From:
Sent: 27 June 2024 18:49
To: Nick Hirst
Cc: DCAdmin
Subject: Planning Application 2024-91236 - Another Contradiction Basements
Attachments: another_contradiction_basement.pdf

The applicant wants to build basements.

Project :	Housing at Lingards Road, Slaithwaite.		
Client :	SB Homes.		
Drawing :	Plot 23 - Alternative layouts with garage.		
Scale :	1:100.	Date :	Nov 2023
Dwg No :	2019 572 Sk 13	Rev :	K

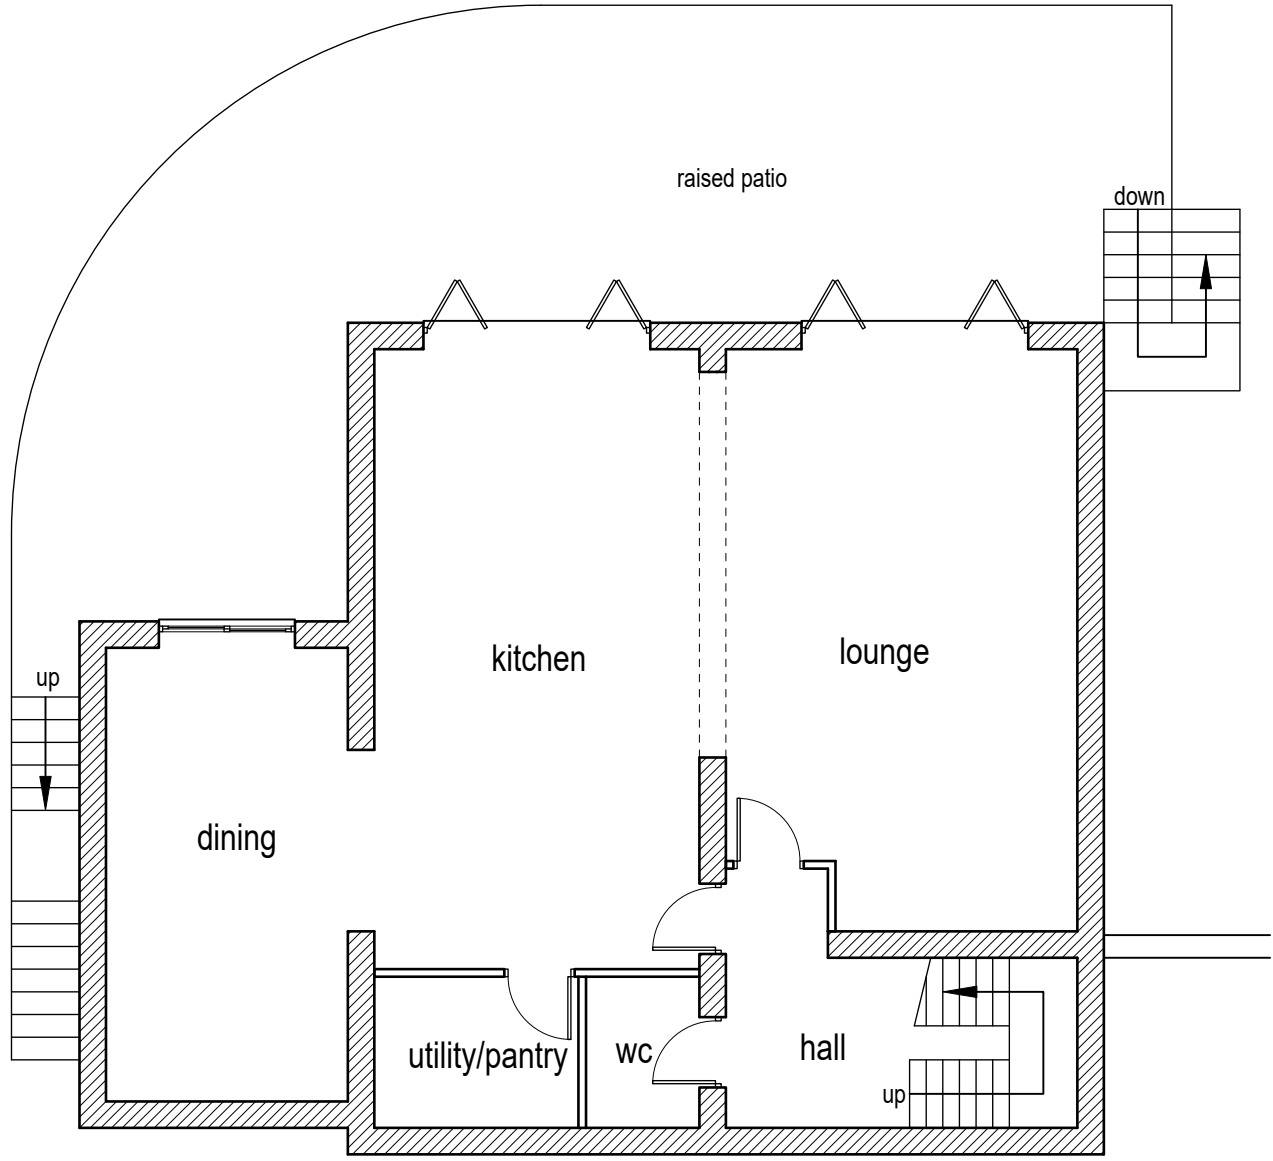
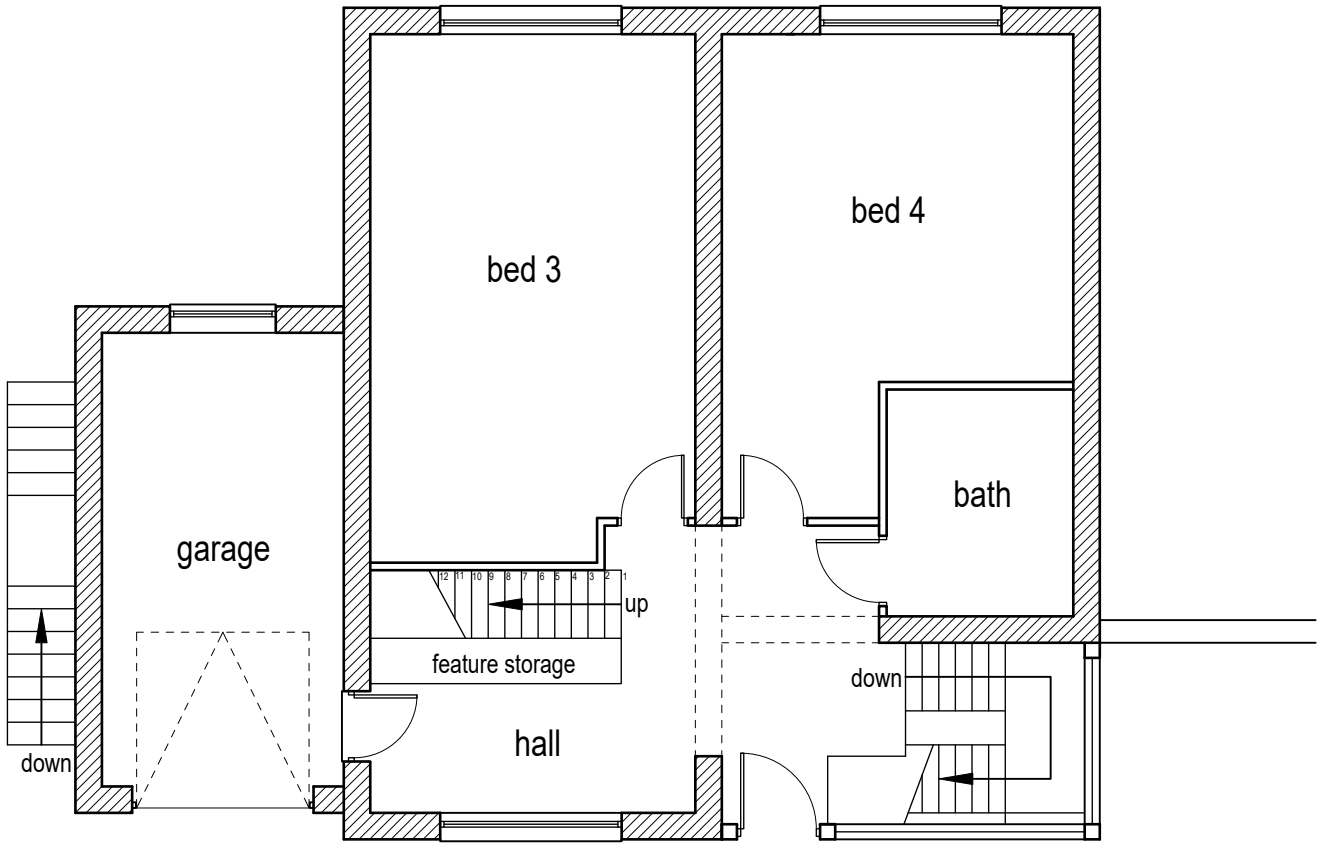
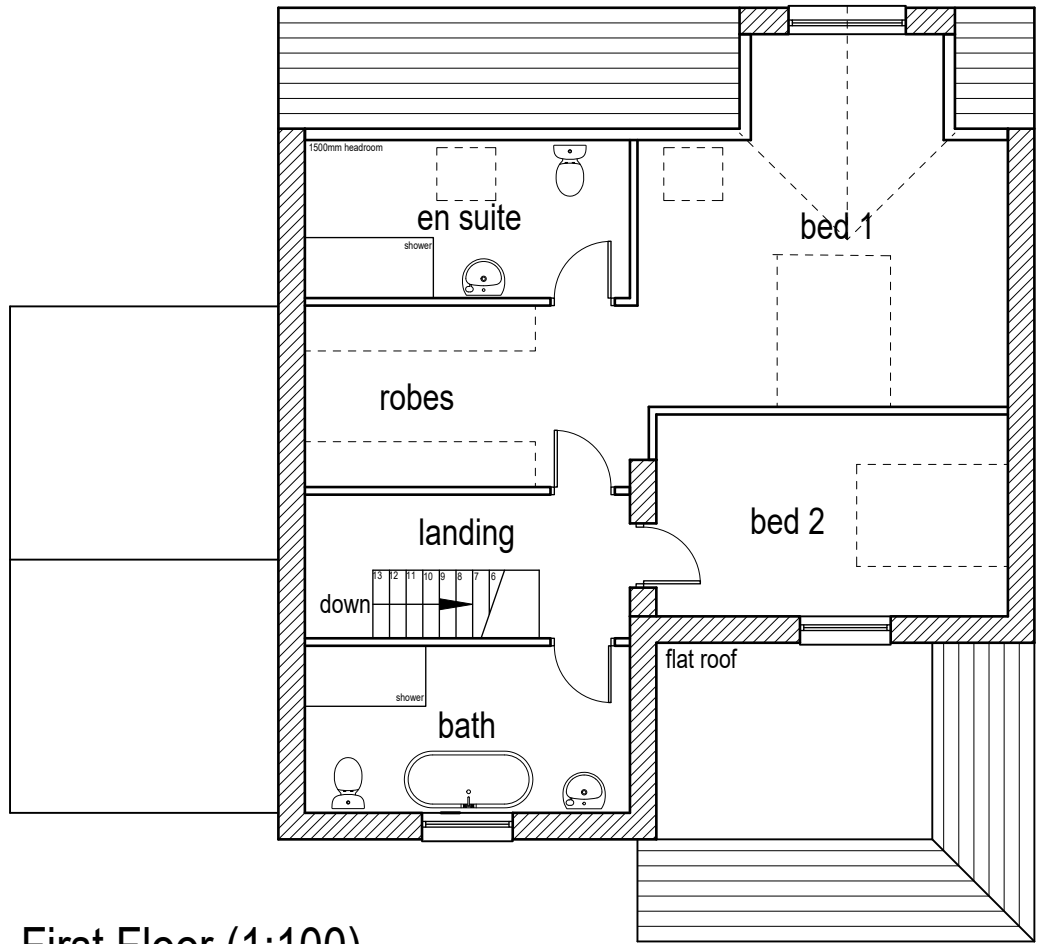
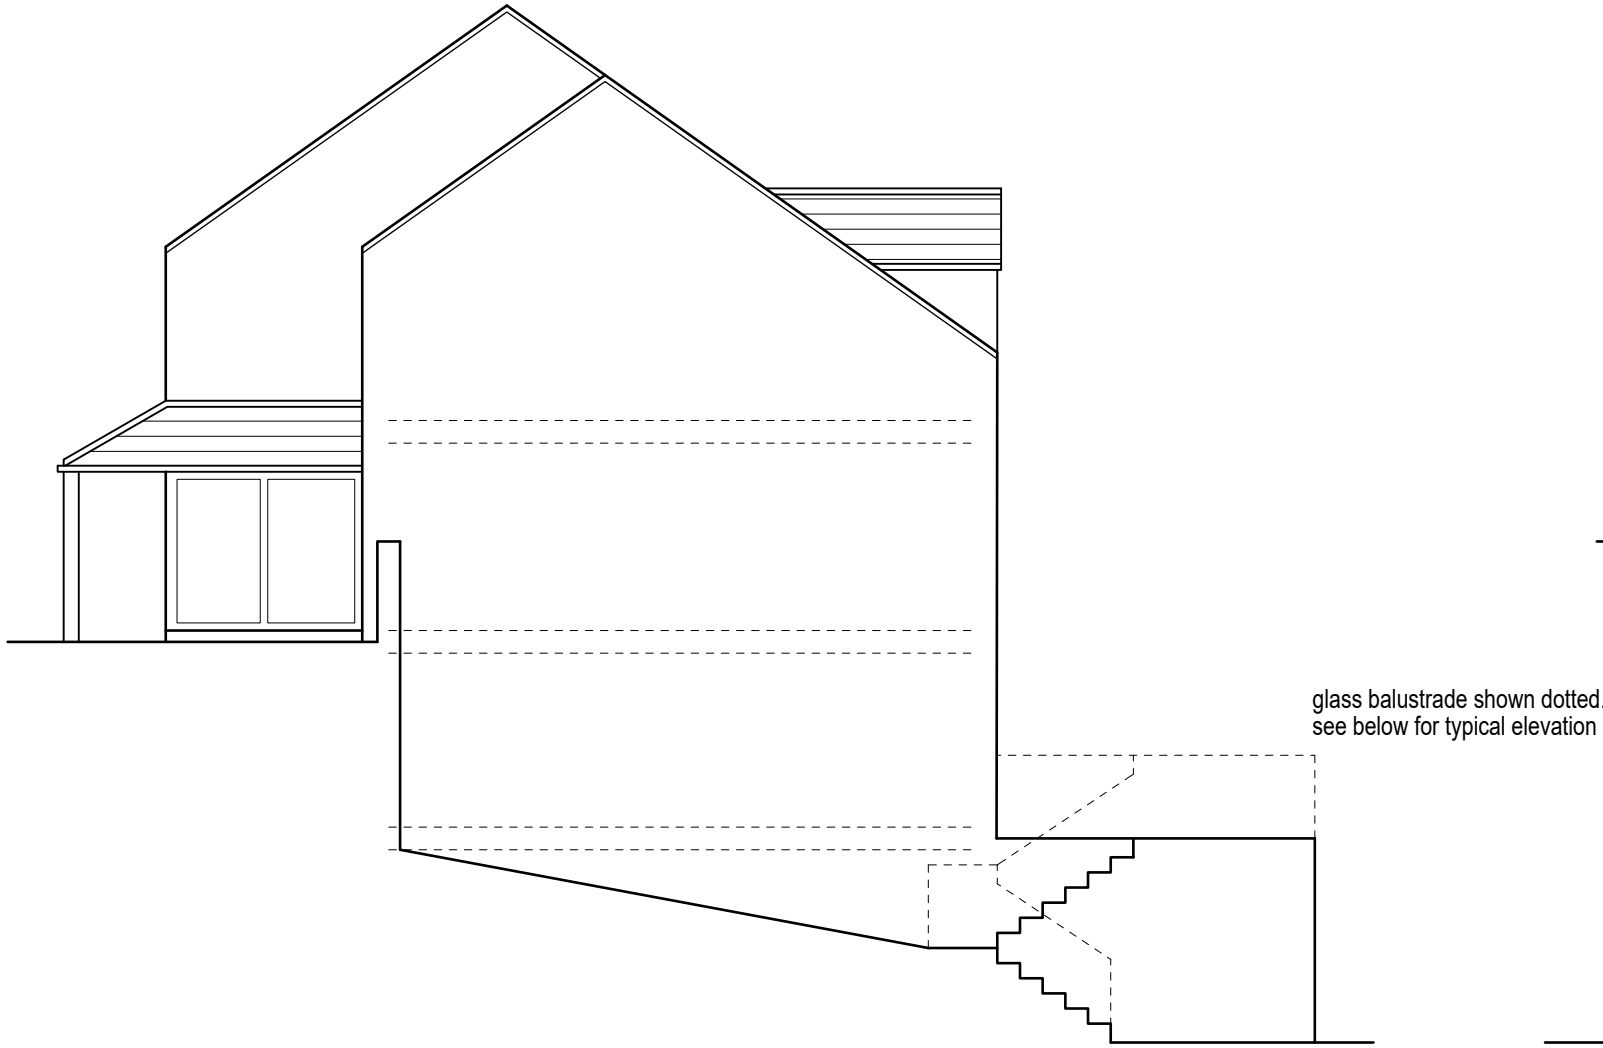
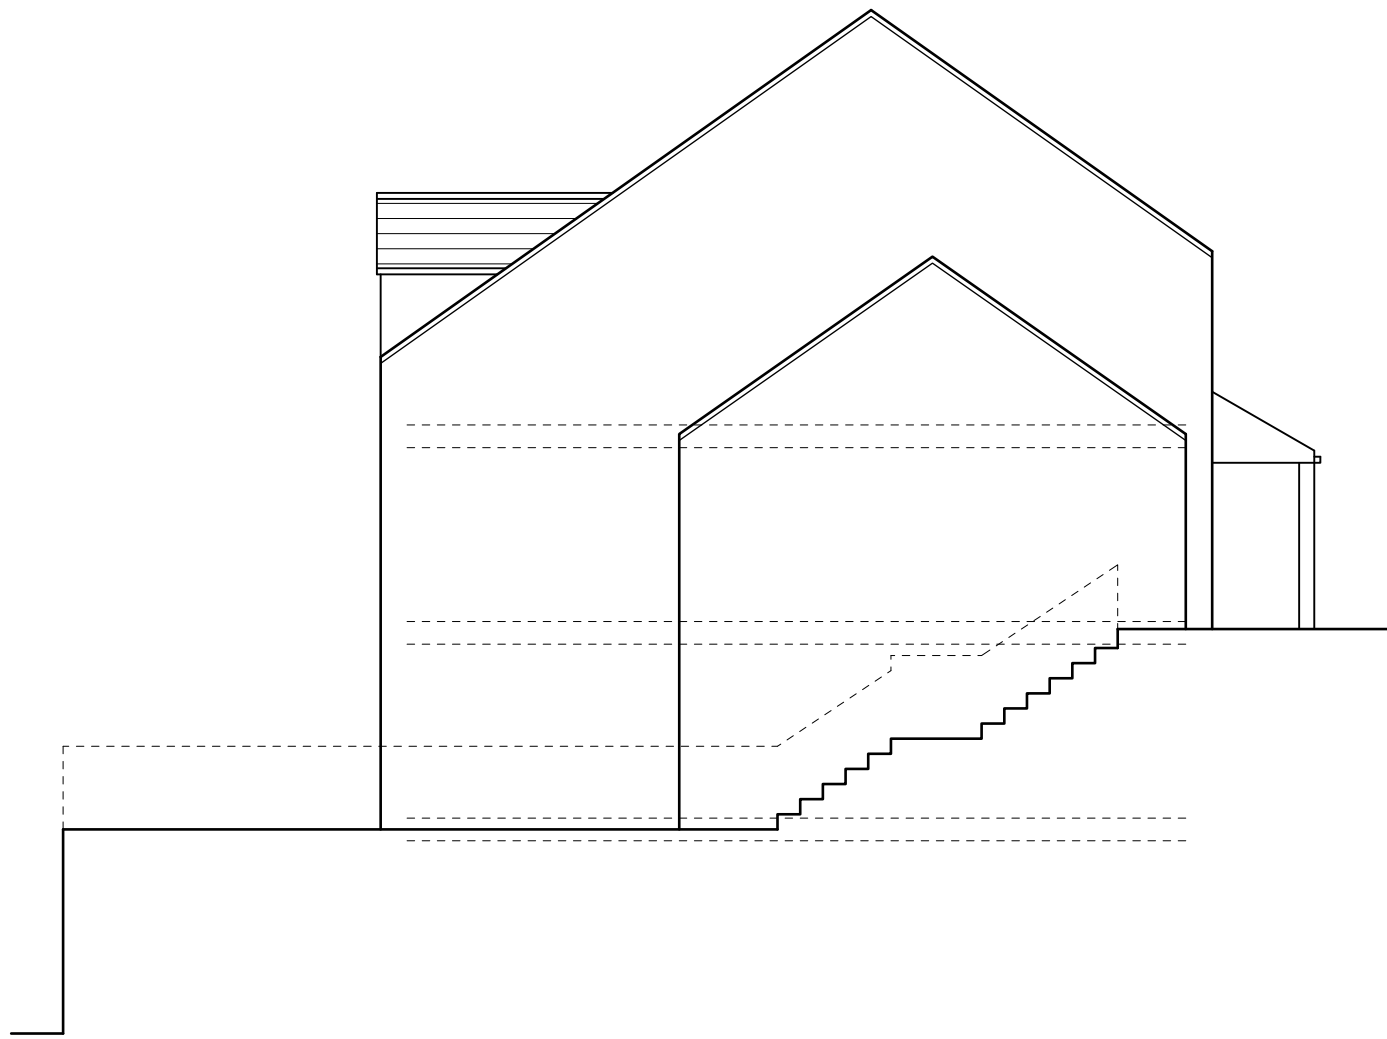
The kitchen and snug, at plot 23, would be under the garage.

But there would be no basement underneath the kitchen and snug, as there would be underneath the rest of the dwelling.
